City of Albuquerque Stormwater Construction Site Inspection Report

General Information					
ESC File No.	D17E095A	Project Name:	Guthrie's Garage		
NPDES Id. No.	NMR1005KO	Location:	3831 Masthead Street		
8/23/2023	Owner	Contractor NMR1005M8			
Operator	Headstart Enterprises LP		Wilger Enterprises		
Contact name & title	Jim Guthrie		John Wilger & DA Gilbert Ramirez		
e-mail	jim@carcrafters.com		jwilger@wilger.com		
Contact Phone #	881-8889		505-345-2854		
COA Inspector	Doug Hughes		Start/End Time:	10:30 AM	
Construction Phase:	Building block walls				
Type of Inspection:	Regular	Storm Event	Post Storm Event >0.25"	311/Complaint	Follow Up
Weather at time of inspection?		Cloudy		Temperature: ~	85
Estimated date of last storm 0.25" or greater				8/8/2023

ENGINEER'S SEAL RONALD R. BOHANNAN NEW MEXICO PROFESSIONAL ENGINEER 7868 4-17-23 RONALD R. BOHANNAN P.E. #7868	3831 MASTHEAD ST ALBUQUERQUE, NM	DRAWN BY pm
EROSION CONTROL PLAN		DATE 4-17-23
		DRAWING
		SHEET # SW-1
		JOB # 2022002

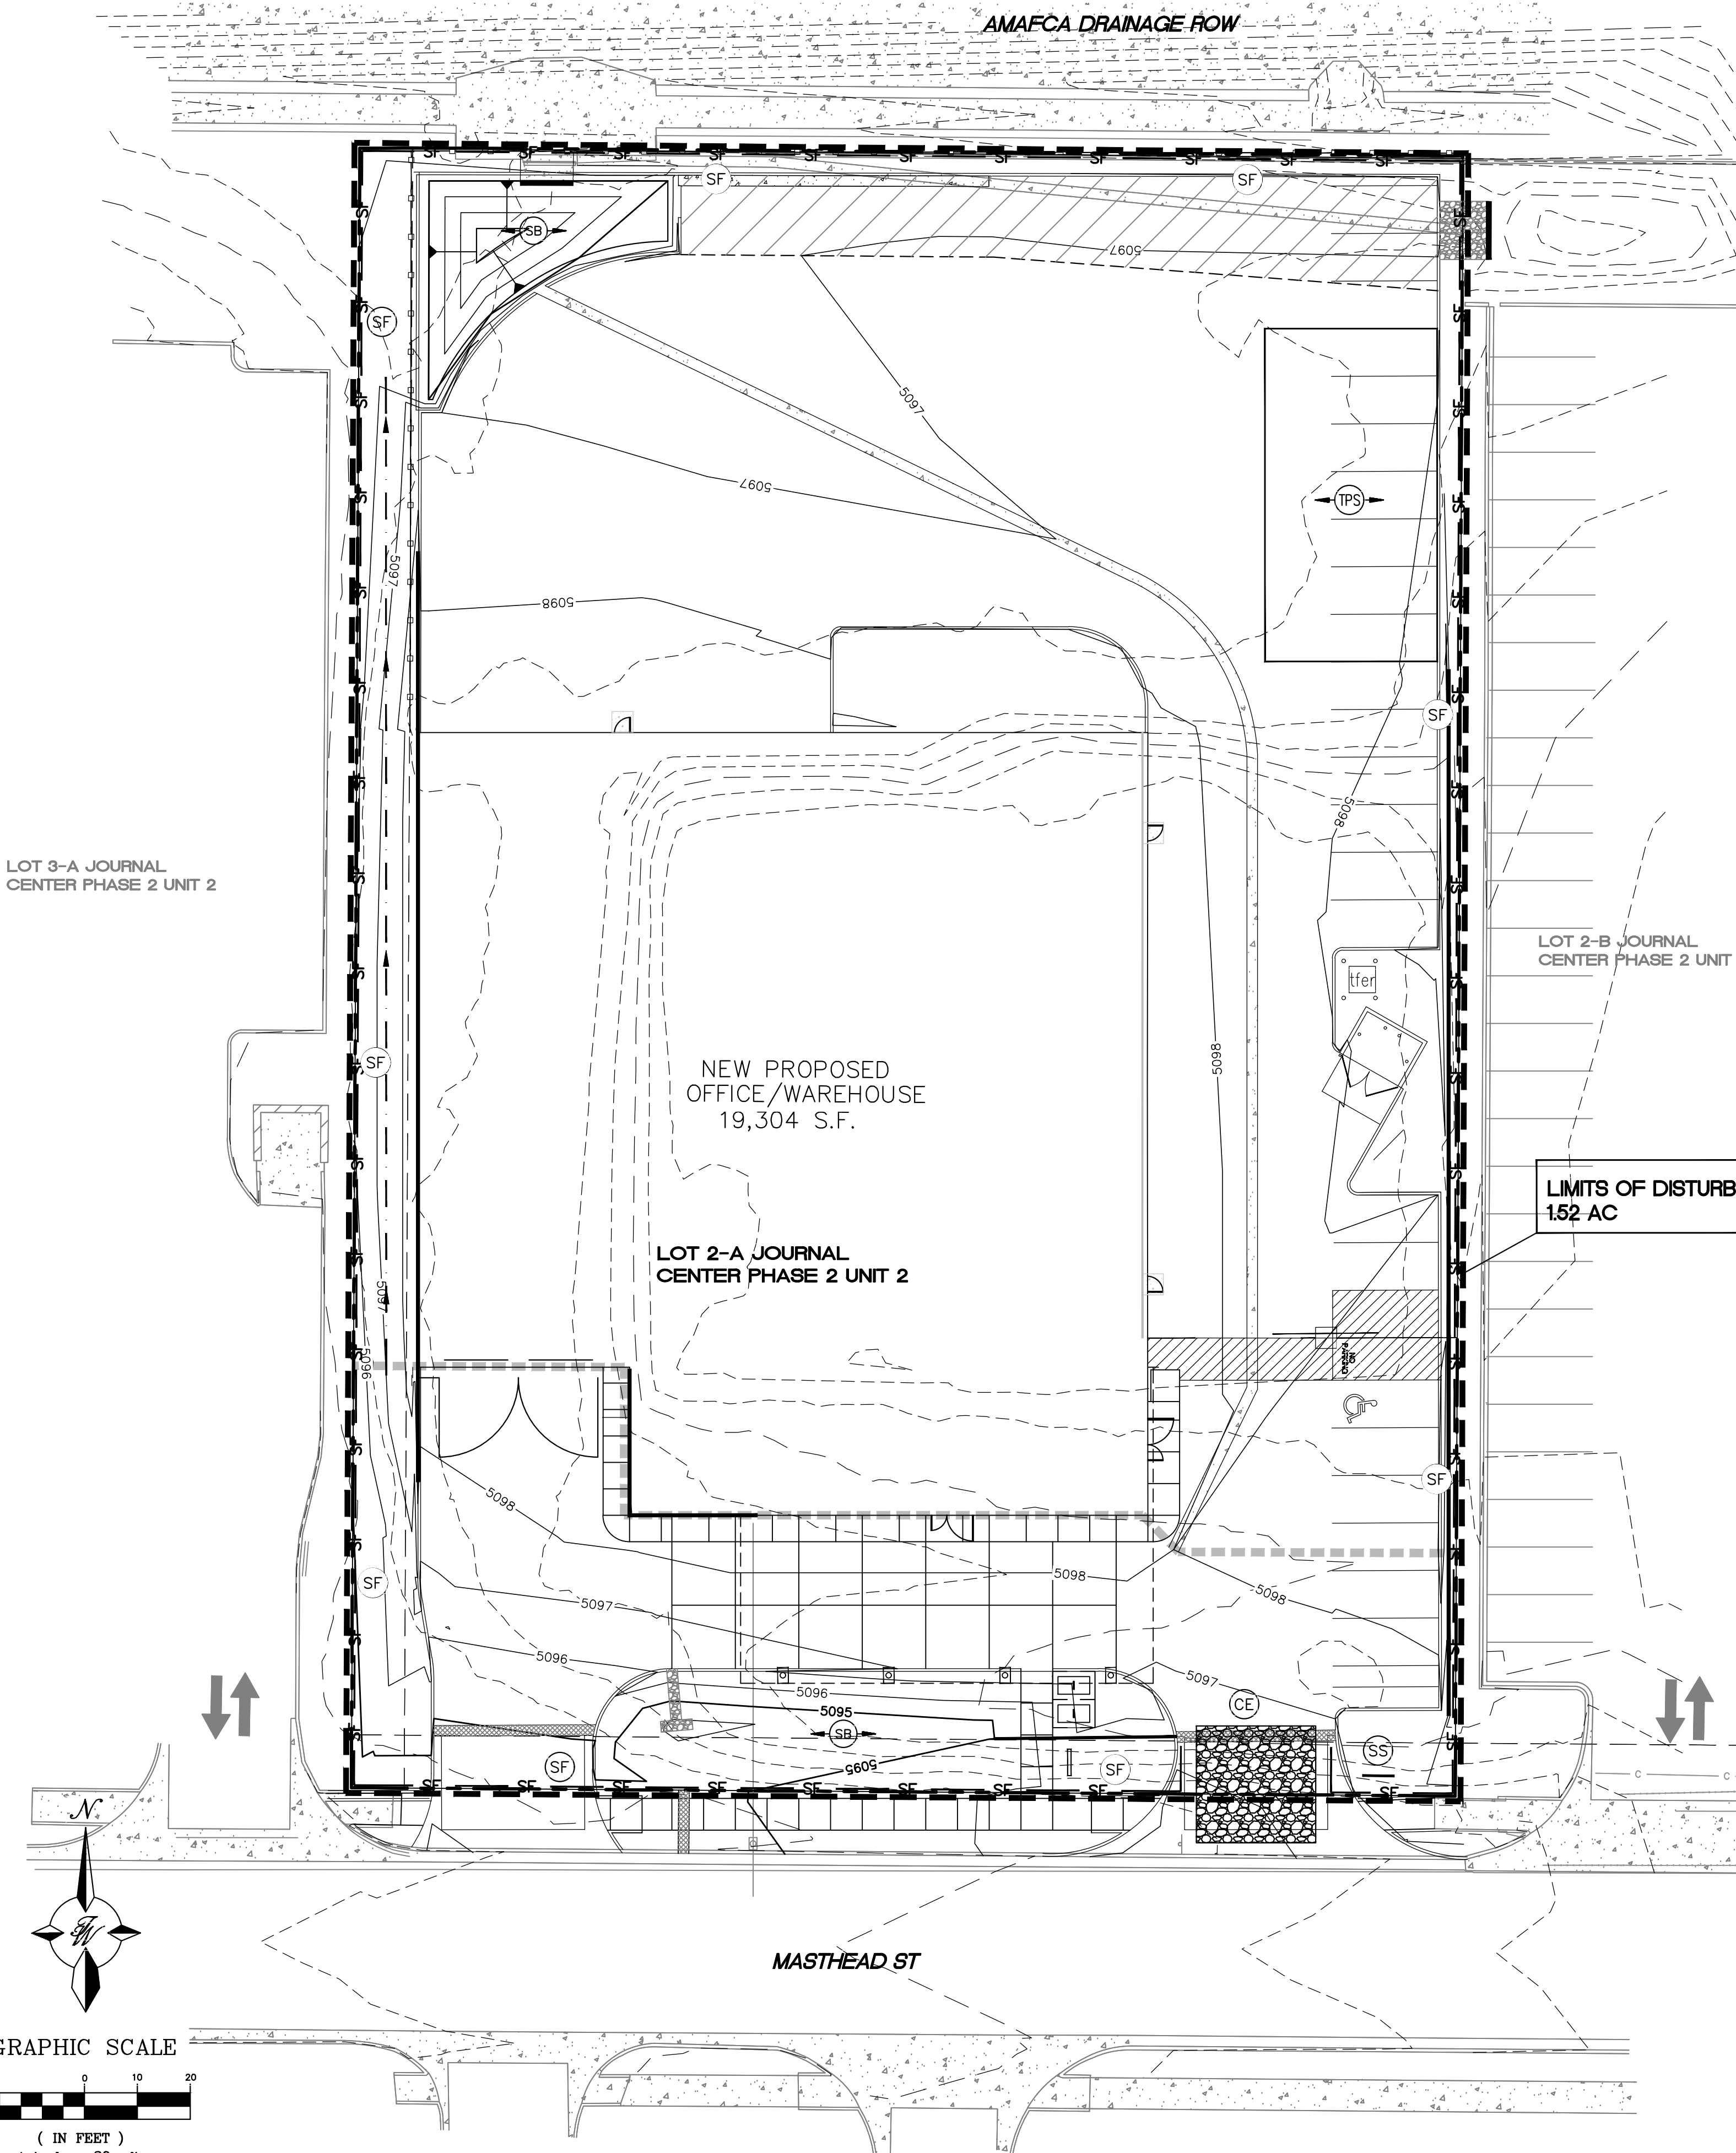
Item Number	Deficiency/ Corrective Action				
1	<p>The SWPPP was still not up-to-date in violation of CGP 7.1 however progress was made in updating it since the last inspection.</p> <p style="text-align: right;">1. Only two out of six stormwater team responsibilities, inspector and installer, are identified in the Stormwater Team list on page 2, and then only by company. <u>The name of the personnel are missing</u> in violation of CGP 7.2.2 Which says "Stormwater Team. Identify the personnel (by name and position) that you have made part of the stormwater team pursuant to Part 6.1, as well as their individual responsibilities, including which members are responsible for conducting inspections." CGP 6.1 says "STORMWATER TEAM – Each operator, or group of multiple operators, must assemble a "stormwater team" that will be responsible for carrying out activities necessary to comply with this permit. The stormwater team must include the following people:</p> <p>a. Personnel who are responsible for the:</p> <p>i. design ,</p> <p>ii. installation,</p> <p>iii. maintenance, and/or repair of stormwater controls (including pollution prevention controls);</p> <p>b. Personnel responsible for the application and storage of treatment chemicals (if applicable);</p> <p>c. Personnel who are responsible for conducting inspections as required in Part 4.1; and</p> <p>d. Personnel who are responsible for taking corrective actions as required in Part 5.</p> <p><i>Members of the stormwater team must be identified in the SWPPP pursuant to Part 7.2.2"</i></p> <p><u>The personnel responsible for Design and Maintenance of stormwater controls is completely missing.</u></p> <p><u>Personnel responsible for taking Corrective Actions is also completely missing. The responsibility for the application and storage of treatment chemicals should be listed and state "N/A" if not applicable.</u></p> <p>2. <u>The corrective action log and/or report was completely missing.</u> The SWPPP was modified. The location of the Construction Exit (CE) on the SWPPP Map changed from east to west. The map modification was signed by (unknown) and dated 6/19/23. But the Corrective Action Report forms and the Corrective Action Log forms were blank.</p> <p>3. <u>The Self Inspection reports weren't signed by the operators.</u></p>

I left a voice message for Mr. Guthrie describing the violations and mitigation requirements.				
2.1	Discharge off site? (Y/N)	no			
4	Self Inspection Reports	ok	Latest report Date:	8/9/2023	
	On 8/23/23 about 3/4 of the violations from the last inspection were mitigated including 1)The property owner information was corrected, 2) The SWPPP certification statements were signed by both operators and they both Delegated Authority (DA) to Gilbert Ramirez, superintendent. 3) BMPs were installed per the corrected SWPPP map.				
Required mitigation: Update the SWPPP with: 1.) Complete Stormwater Team, 2.) Corrective action report and log, 3.) Operator or DA signatures on all reports.
